SFD211871
PLAT 871
REF MER166
RR-5

6875 JUANITA ST parcel 52082-24-010
PLAT 871 ZONE RR-5 lot 22263 SQFT

DISAPPROVED
Plan Review

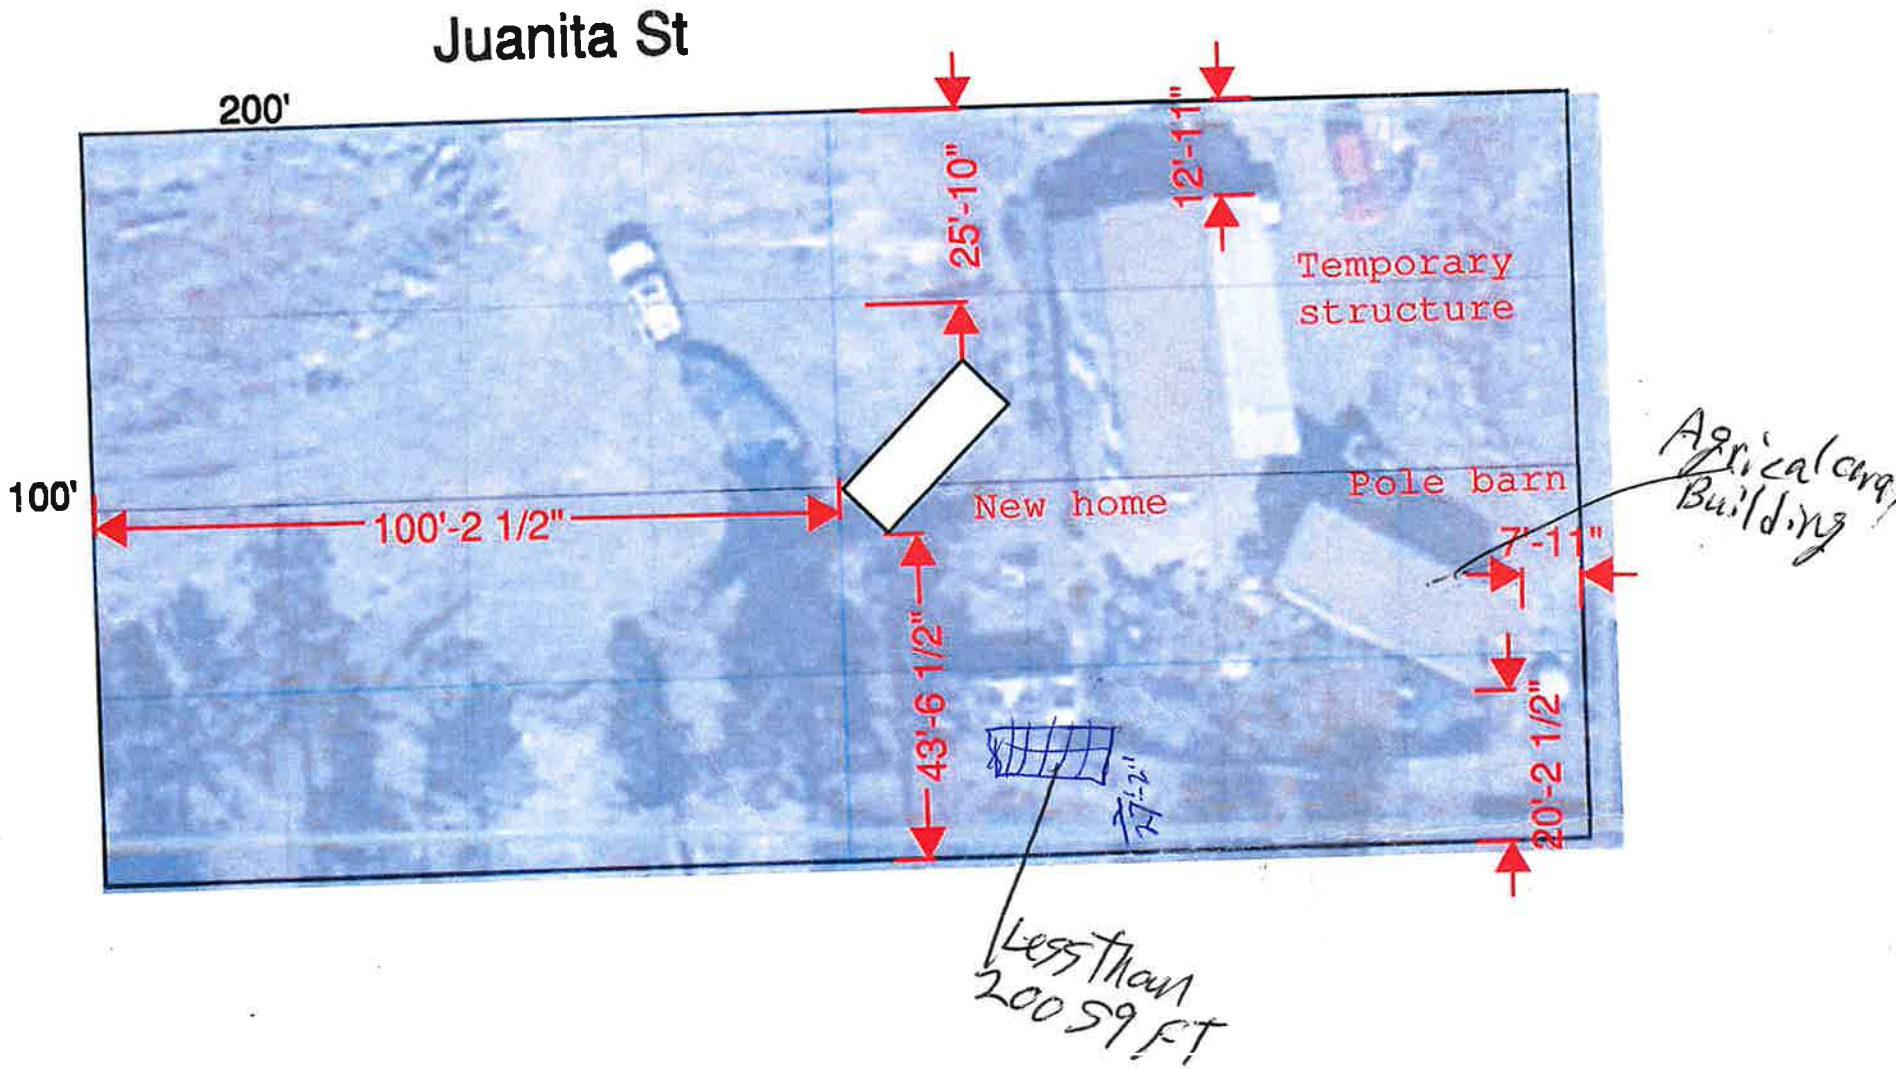
All three structures are encroaching in the 25' setbacks. The applicant must contact the planner of the day in regards to the encroachments about a dimensional variance. One can be reached at 719-520-6944 or via e-mail at dsd-pod@elpasoco.com. Also, once the variance is complete a BESQCP will be required with the submission into PPRBD's system. An application is enclosed in the plan set.
